Development Outside the Red-Line Boundary and Separation from Undeveloped Land

The photographs and submitted site plan below raise two related concerns about the western side of Plot 23.

This is particularly important because 2026/91657 seeks permission for further openings and alterations facing towards that boundary and the undeveloped land beyond it.

Rev B	03/06/2026	Updated for planning submission.		
Rev A	24/09/2025	Minor amendments, dimensions added.		
Project :		Housing at Lingards Road, Slaithwaite.		
Client :		SB Homes.		
Drawing :		Plot 23 - OPTION 1.		
Scale :		1:100.	Date :	May 2025
Dwg No :		2019 572 Sk 15	Rev :	B

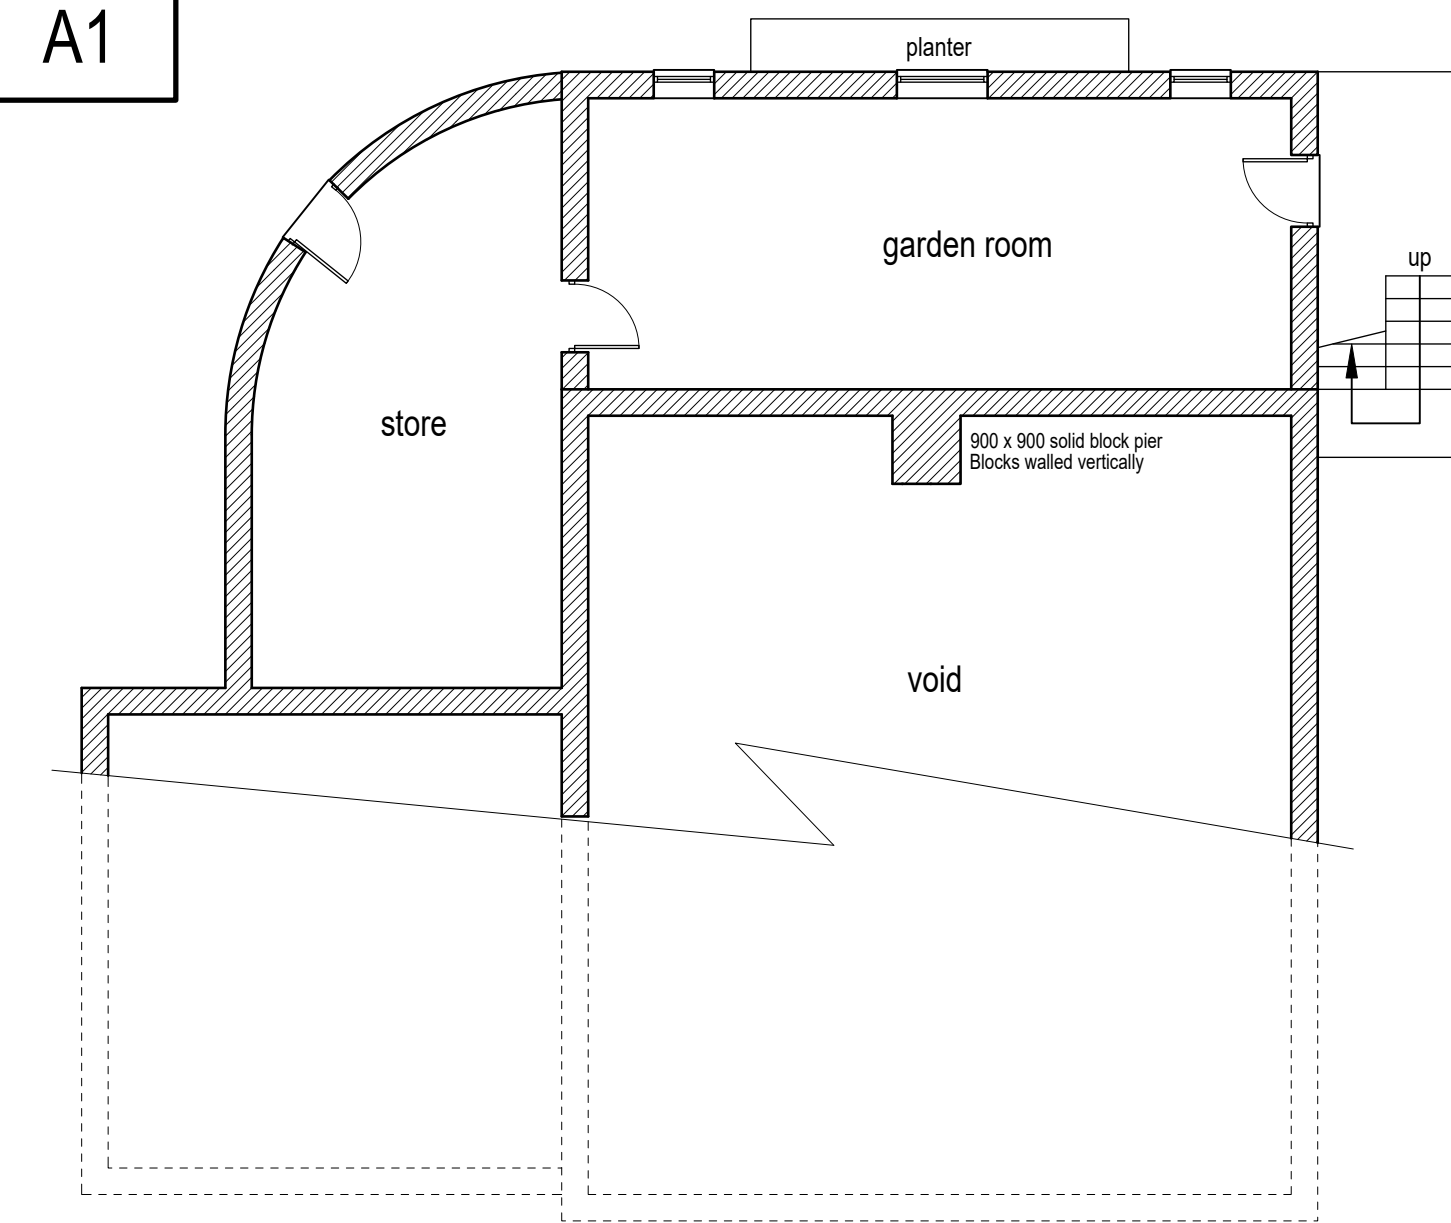
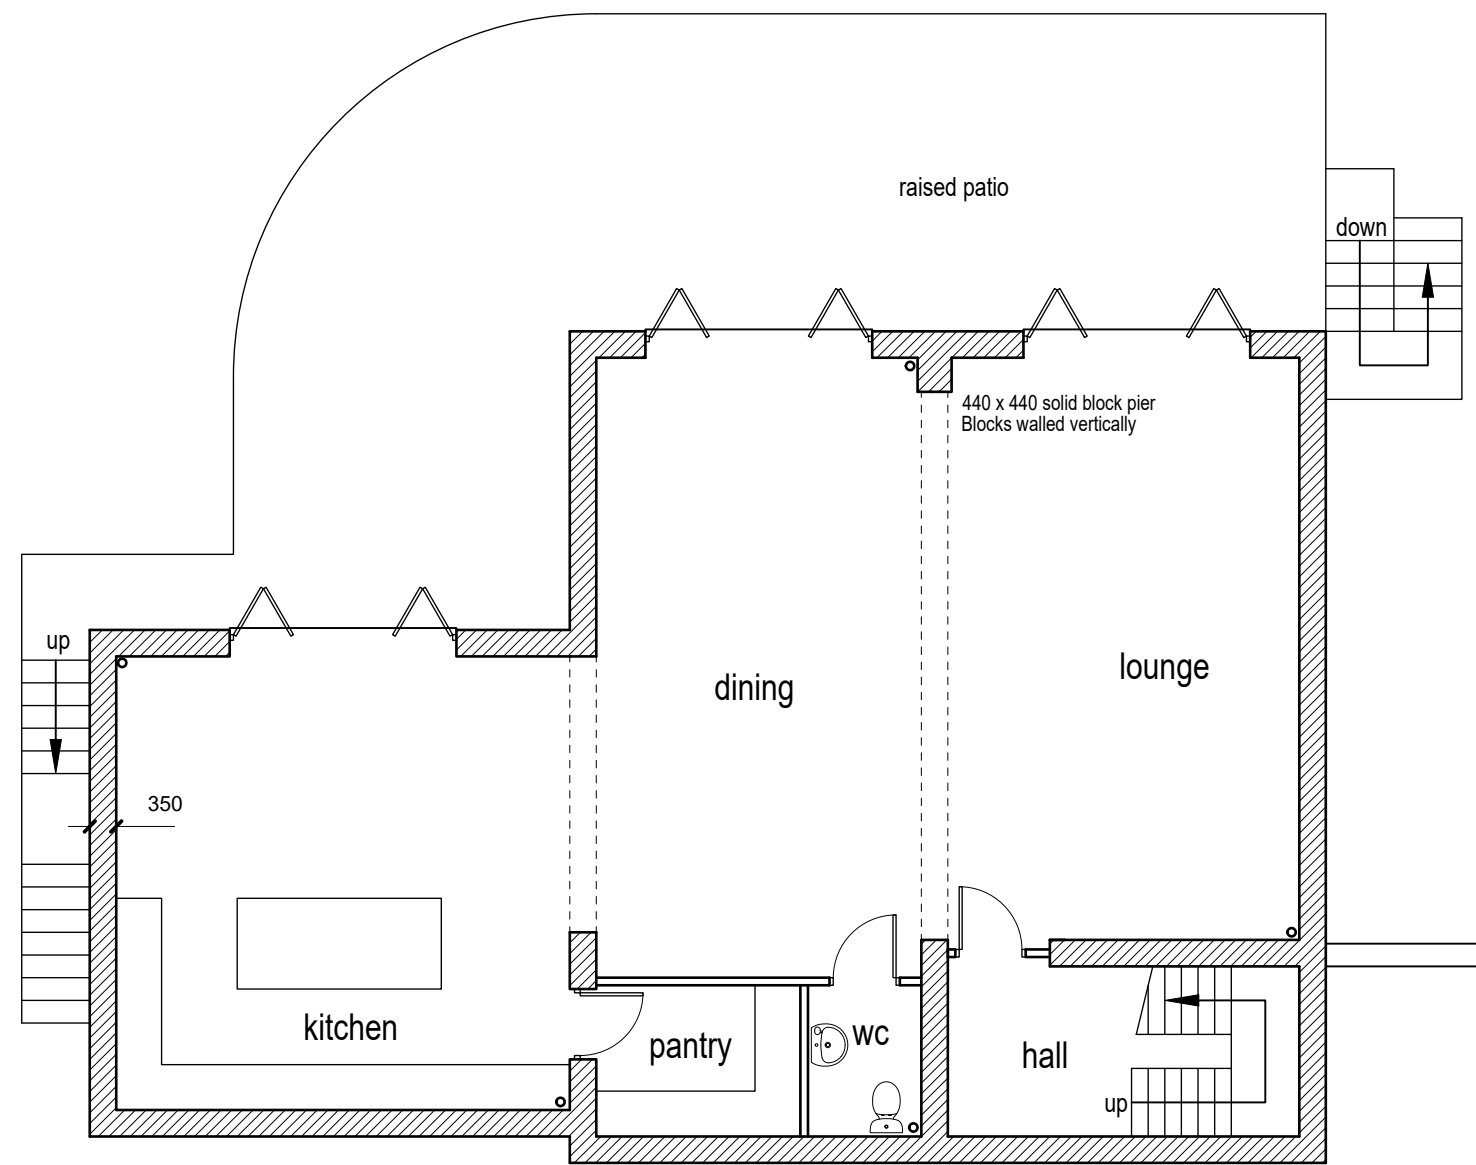
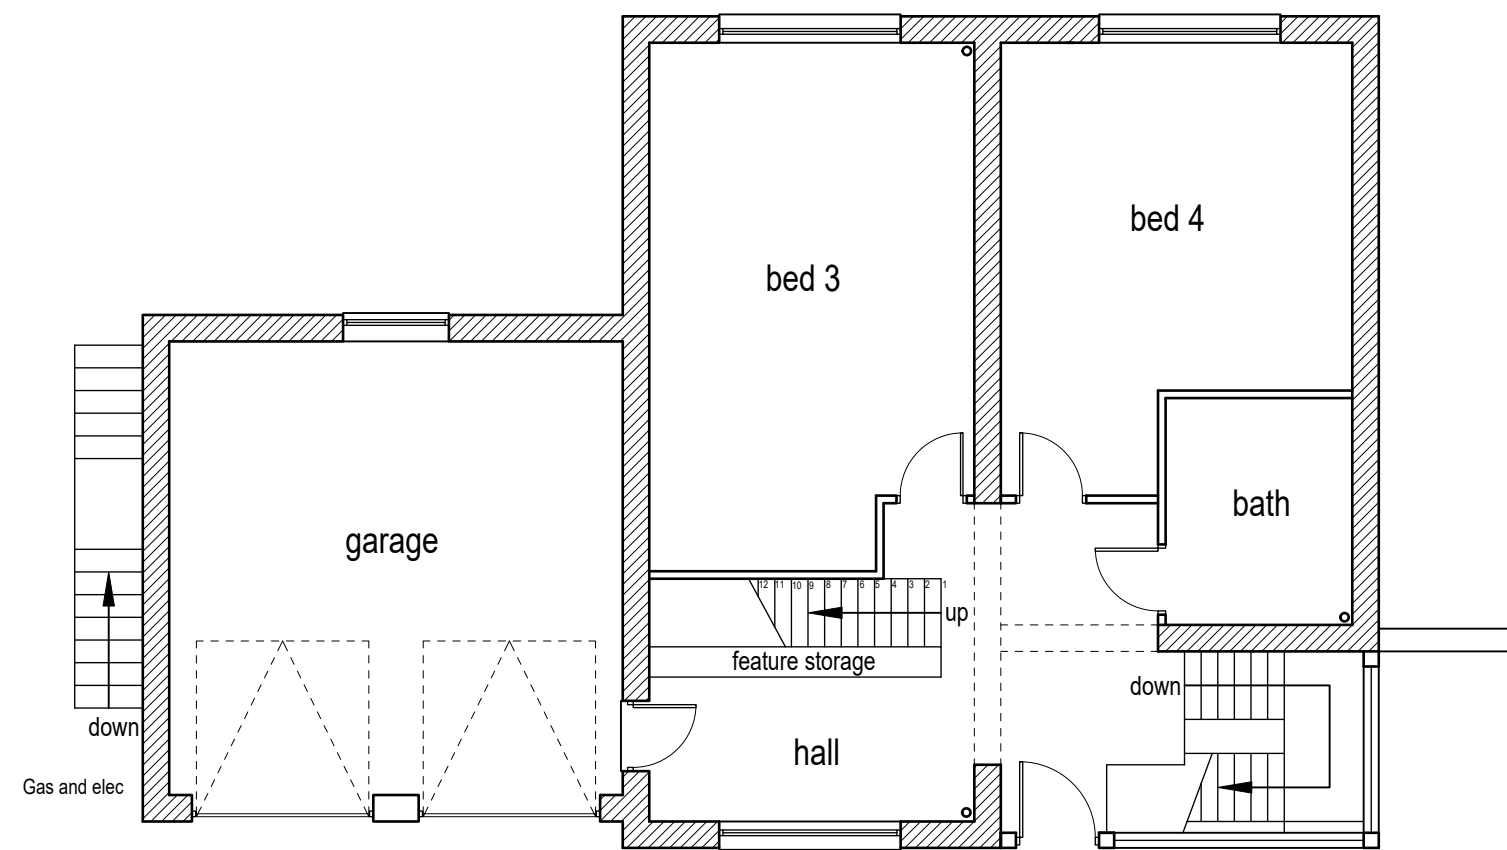
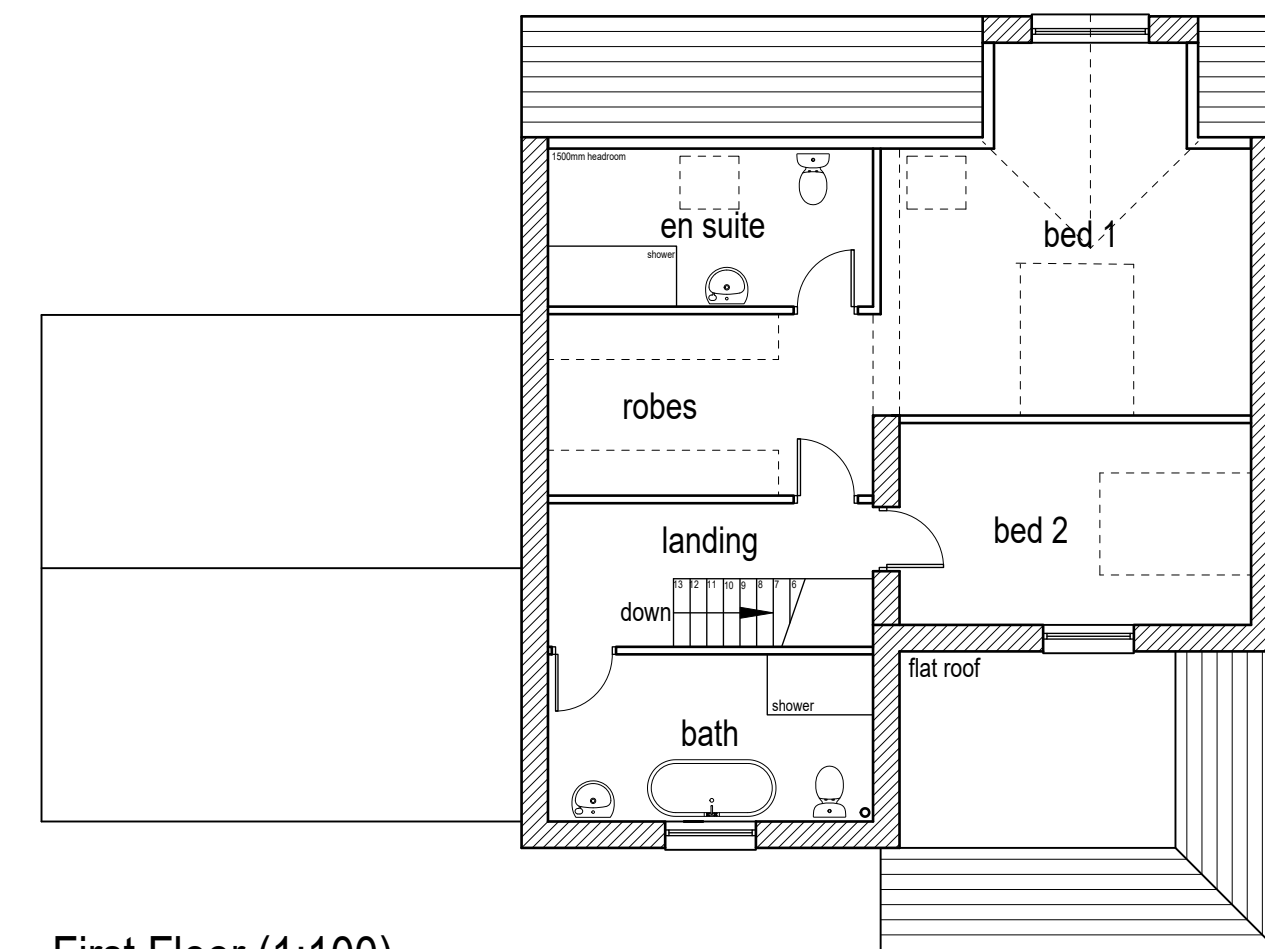
The proposed patio-door opening is even closer to the boundary, at approximately 4.93 m. If this opening serves habitable accommodation, it should likewise be assessed directly against the 10.5 m guidance. In any event, its scale and proximity to the undeveloped land should form part of the Council's assessment of the cumulative effect of the additional west-facing development.

1. establish the planning status of the removal of the former wall and the excavation/regrading undertaken beyond the western red-line boundary;
2. confirm that the land beyond that red line remains outside the application site for the purposes of assessing 2026/91657;
3. assess the two garden-room windows specifically against the Council's 10.5 m separation guidance; and
4. separately assess the approximately 4.93 m patio-door relationship, including whether it serves habitable accommodation and whether its proximity to the undeveloped land is acceptable.

Part outline site plan (1:500)

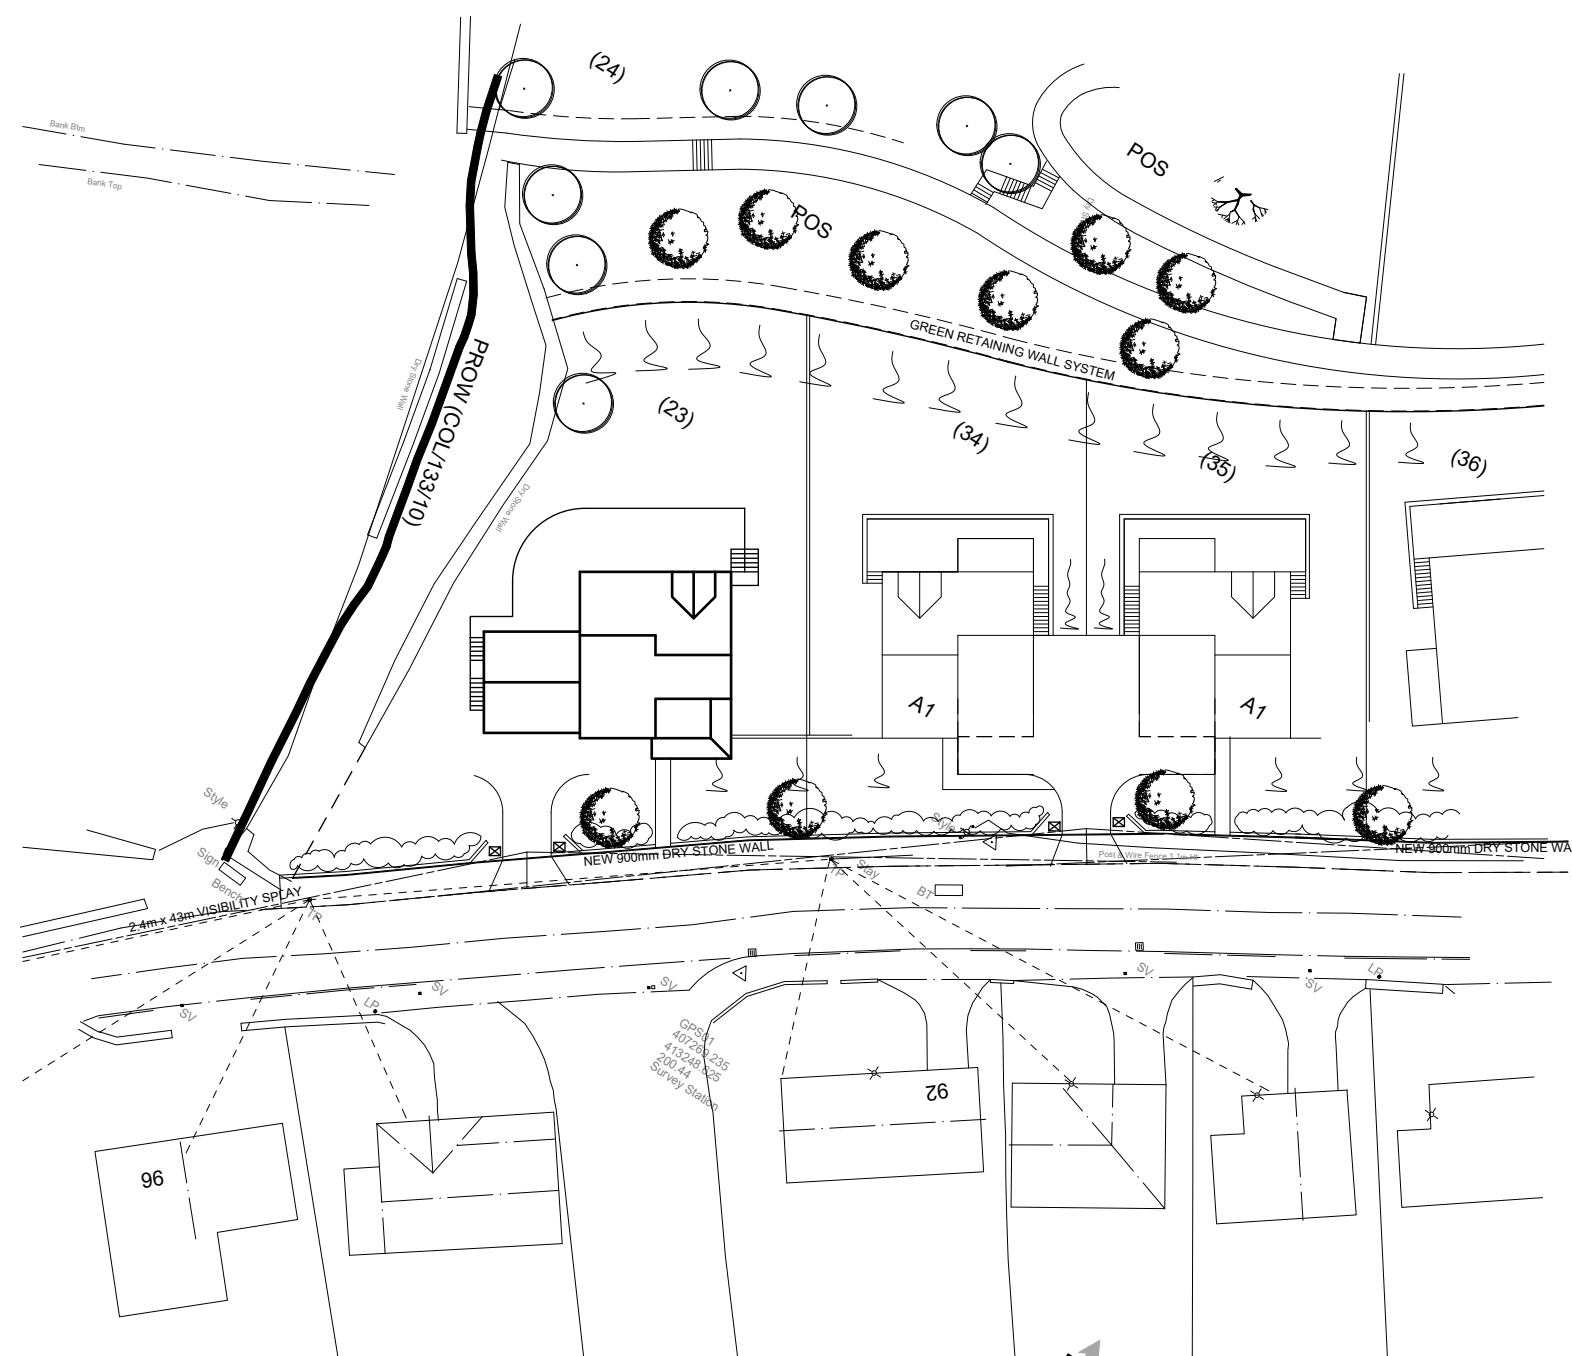
The accompanying site-plan extract measures the relevant distances from the proposed openings to the western red-line boundary at approximately:

- Western garden-room window – 6.47 m
- Central garden-room window – 8.97 m
- Patio-door opening associated with the extended garage arrangement – 4.93 m

Kirklees' Housebuilders Design Guide advises a typical minimum separation of 10.5 m between a habitable-room window and the boundary of adjacent undeveloped land.

The two garden-room windows are therefore substantially inside that advised separation distance. The western window is approximately 4.03 m short of the guidance and the central window approximately 1.53 m short.

These are not marginal differences. The proposed alterations would introduce or retain substantial glazed openings facing towards land outside the application site at distances materially below the Council's normal amenity standard.
